**FINAL DRAINAGE REPORT
ADDENDUM NO. 2
BENT GRASS RESIDENTIAL FILING NO. 1
FOR
BENT GRASS EAST COMMERCIAL
FILING NO. 3**

PCD Filing No.: SP-20-010

Job no. 2177.64

|            | <b>BENT GRASS EAST COMMERCIAL FILING NO. 3</b><br>PRELIMINARY PLAN<br>PRELIMINARY GRADING PLAN |              |         |         |      |

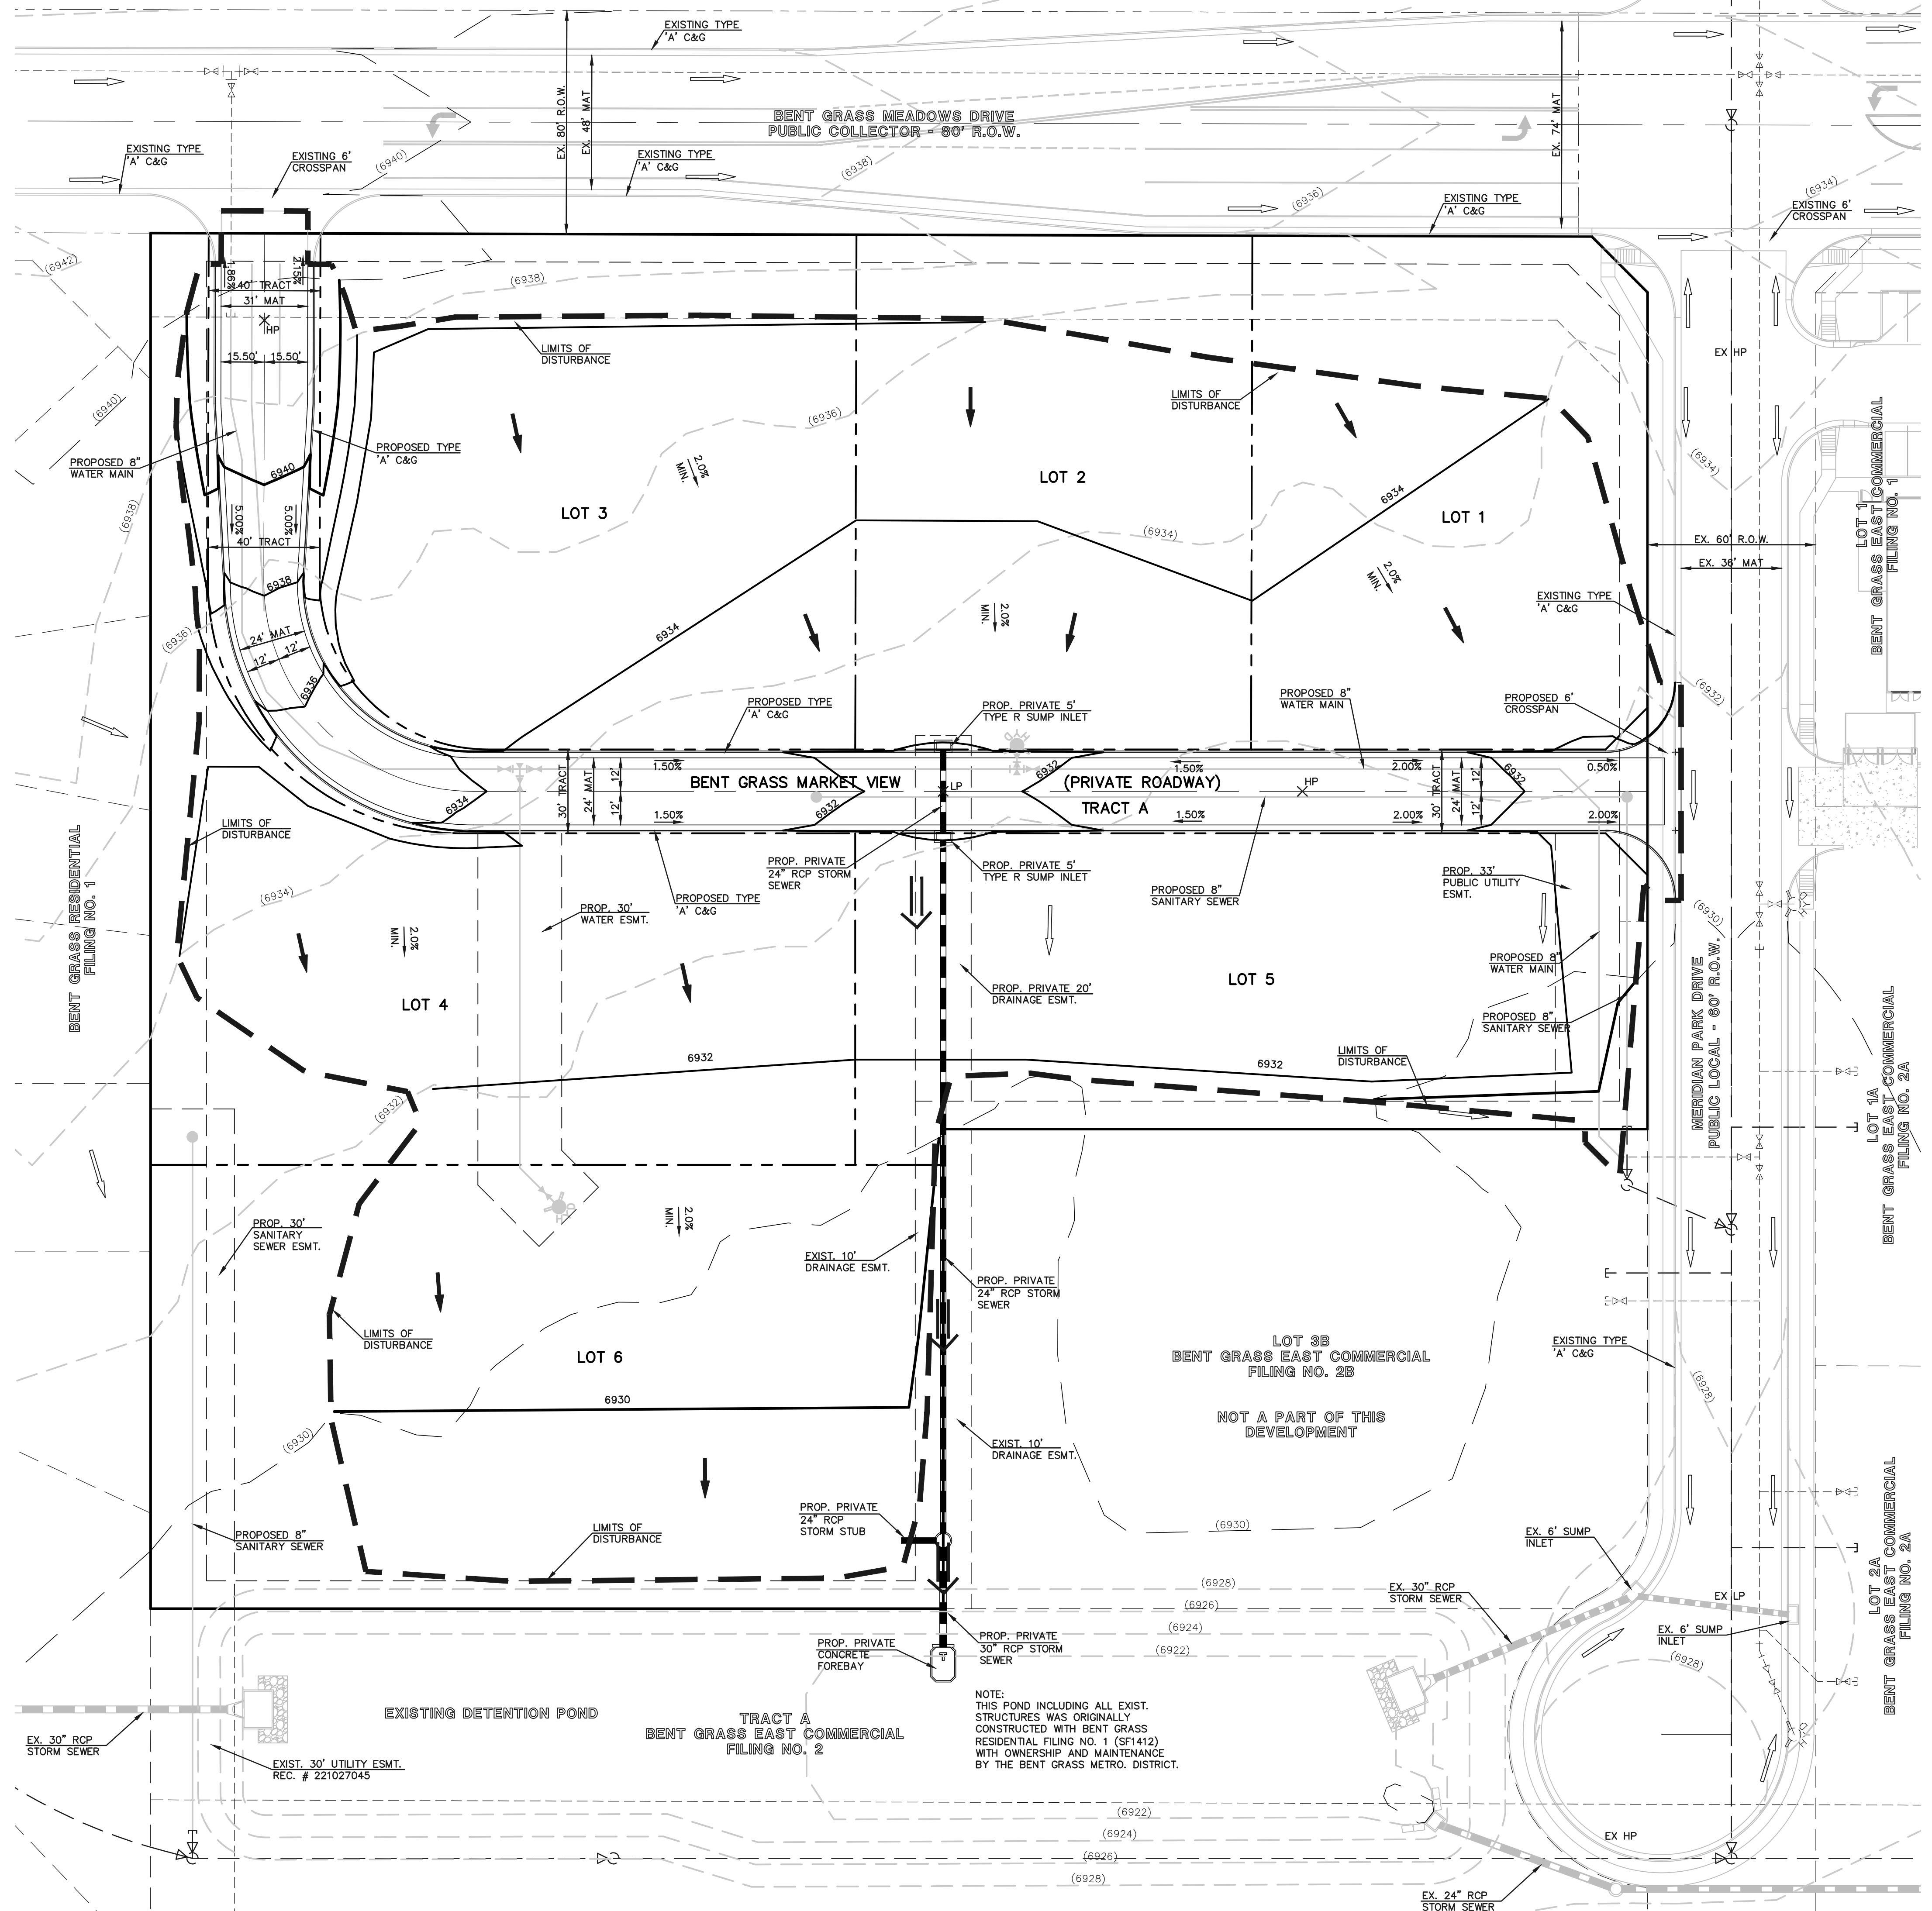
Per the drainage map, it appears that the majority of the runoff from basin C will sheet flow into the pond as opposed to being routed to the 24" RCP. Is the intent for the 24" RCP to be capped for connection by the developer of lot 6? Revise accordingly.

Please state whether the outfall of this flow is consistent with the previously approved report.

Please indicate how these flows are conveyed to the existing pond.

Per the provided drainage map this basin does not drain to the existing southerly pond. Per ECM appendix I, 100% of the development site must be captured. ECM I.7.1.C.1 allows for 20% not to exceed 1 acre of the applicable development site area to not be captured. If your intent is to use this allowance please state it in the report or provide another exclusion allowed per the criteria for not provided water quality for this basin.
